Your Ref: OWPC21014
Our Ref: EP/179/18/PL 12-12-2018
Please ask for:
Mrs A Gardner

Demolition of existing house & erection of 3x 3 bedroom houses together with landscaping, car parking and fencing.

Gladwyn The Street East Preston

Project: Proposed new homes; Gladwyn, The Street, East Preston BN16 1HT			
Drawing: Block plan			
FOR: Mrs. J. Simmonds & Mr. P. Beamish			
Drawn: PKS	Date: November 2018		
Scales: 1:200	No: 2386/01/03/A		
To scale when printed on A3

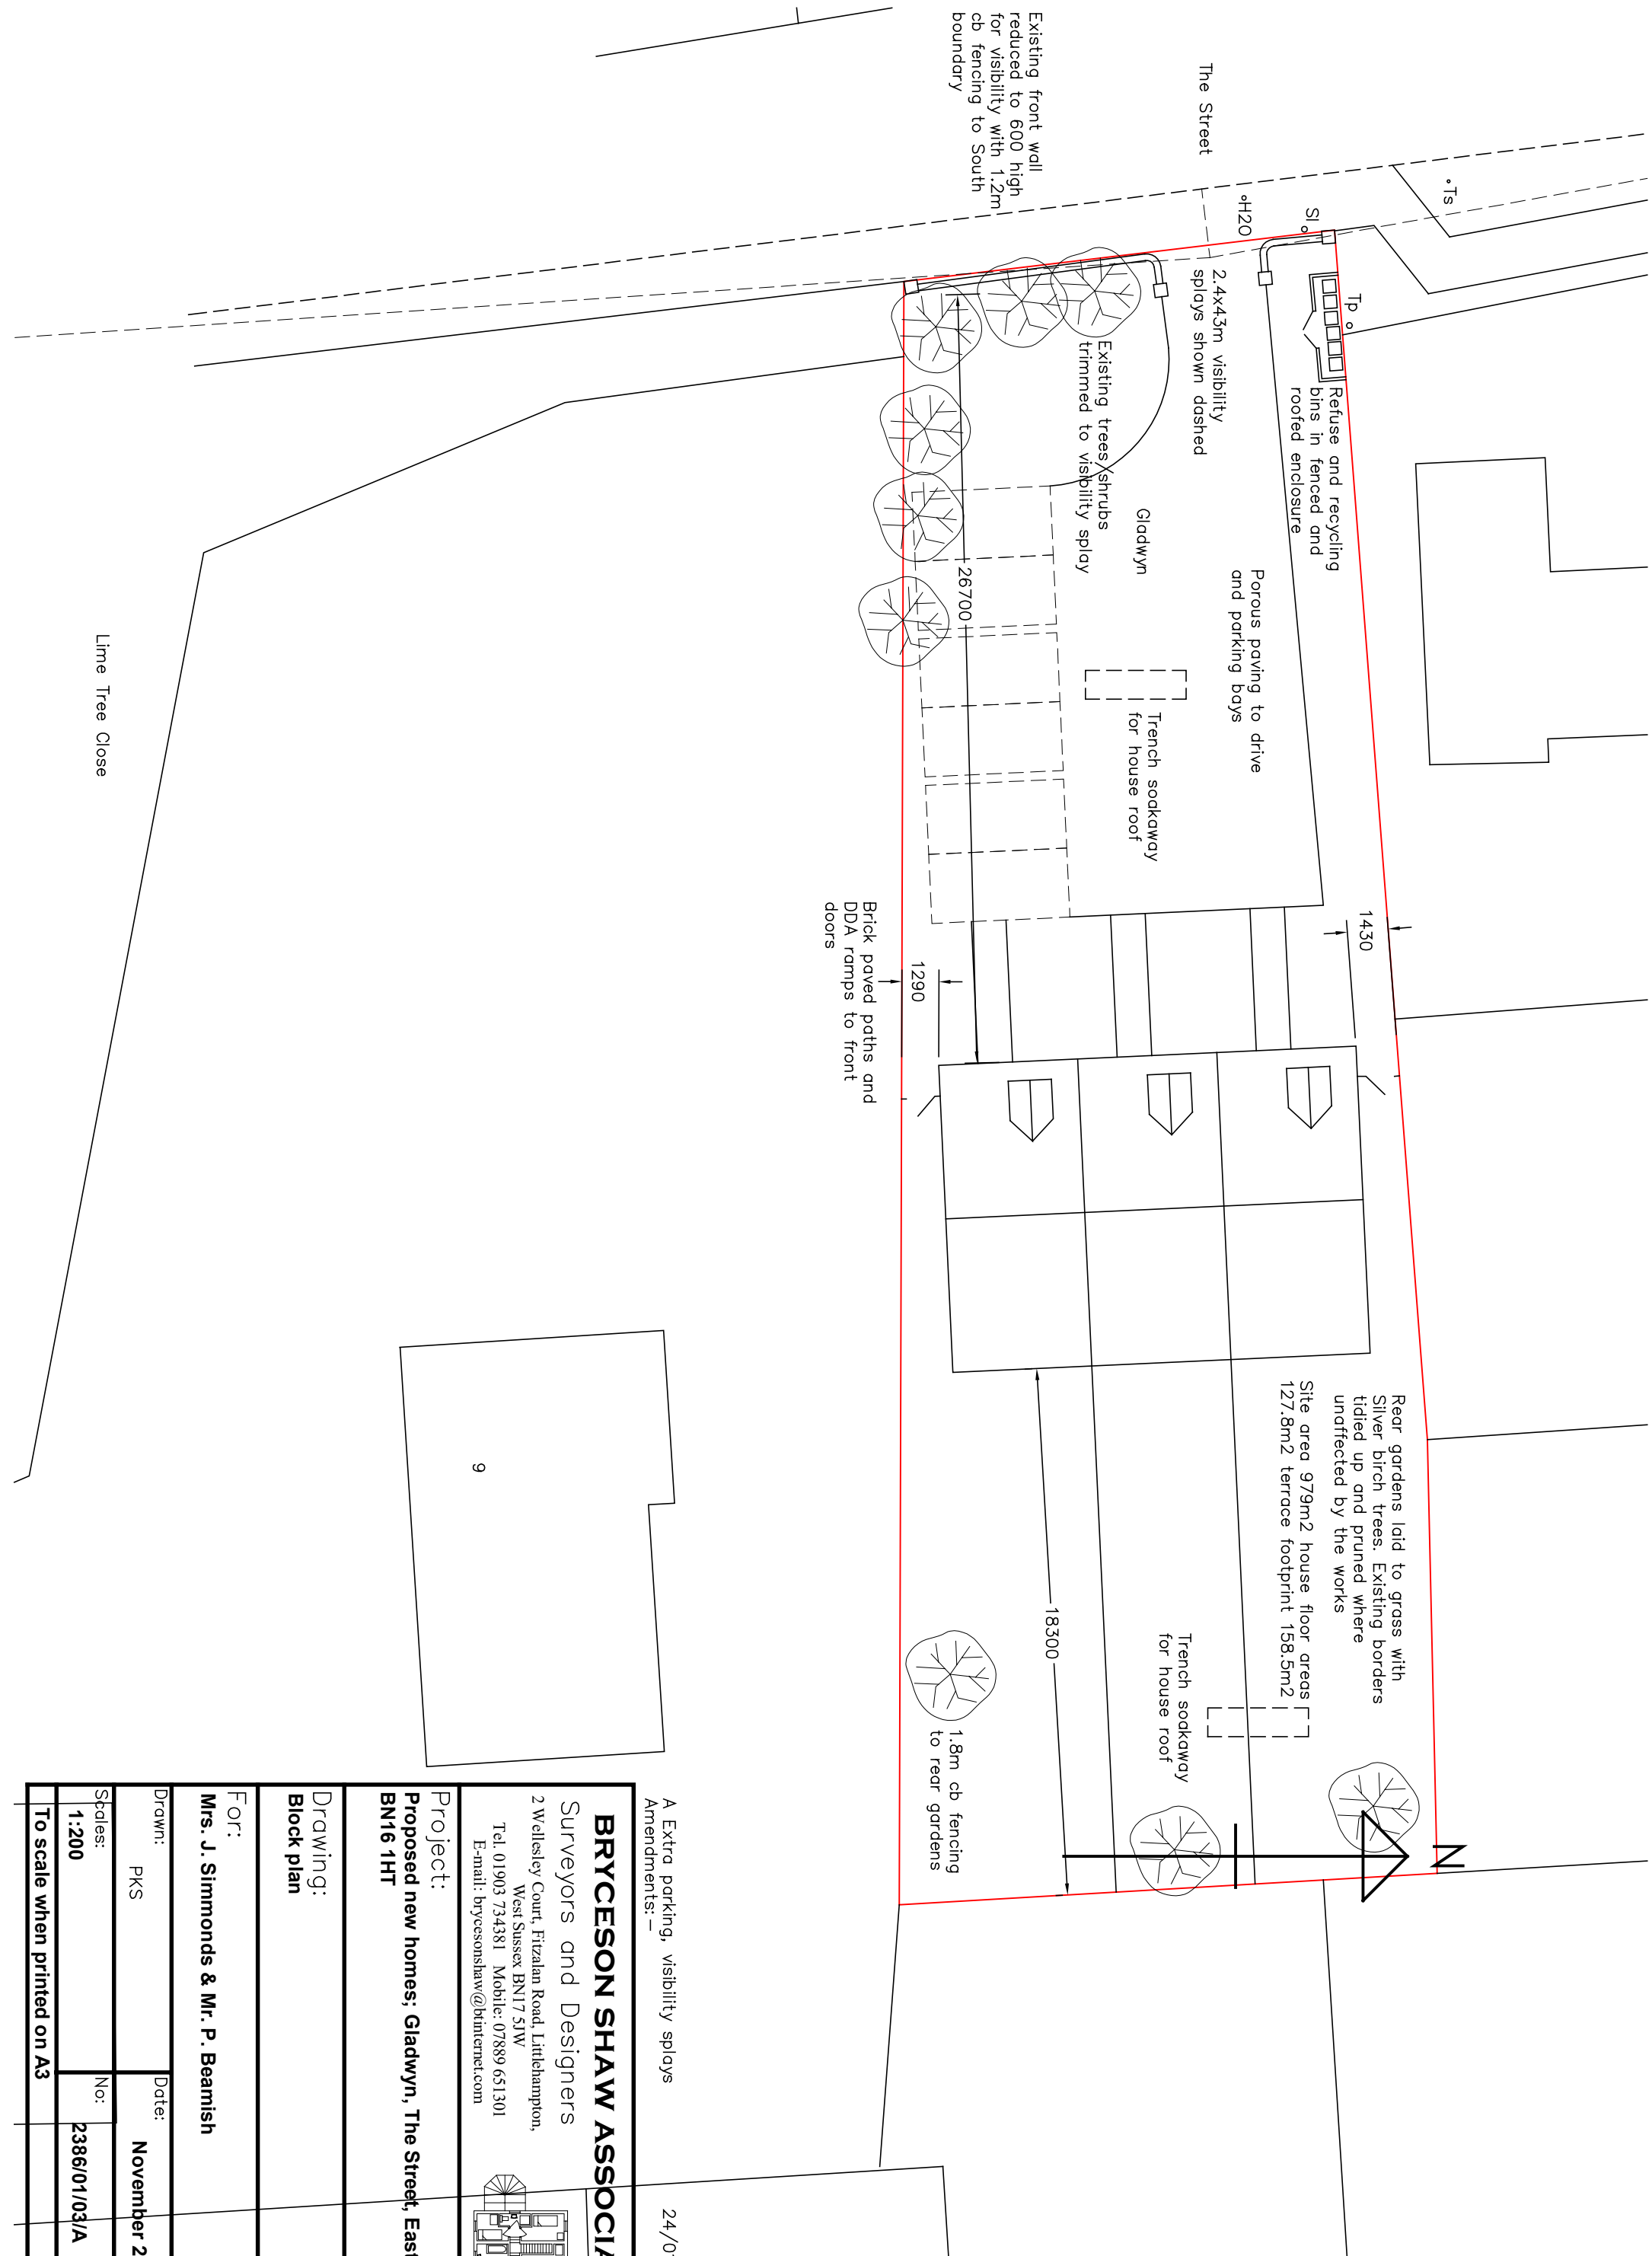
Three properties on this site is too intense for the size and location of the plot. The 4 parking spaces allocated for 3x 3 bedroomed terraced houses is less than government recommendations of 1.75 per property in a low intensity urban area. The Width of each space, according to the scale plan, is also less than the minimum government recommendation. Thus there is a real likelihood of regular parking on the street outside the properties. This street is narrow, busy and on a bus route where double deckers pass every 5 minutes during the day. The properties opposite the site, including mine, already have a very difficult time both backing a car out of our driveways or indeed driving out forwards safely. This safety concern is greatly exacerbated if a vehicle is parked opposite. The view of the drivers of vehicles approaching from the south is compromised by a slight bend in the road and the shape of (listed) boundary walling. Similarly the view of the driver of a vehicle exiting a drive is extremely limited.
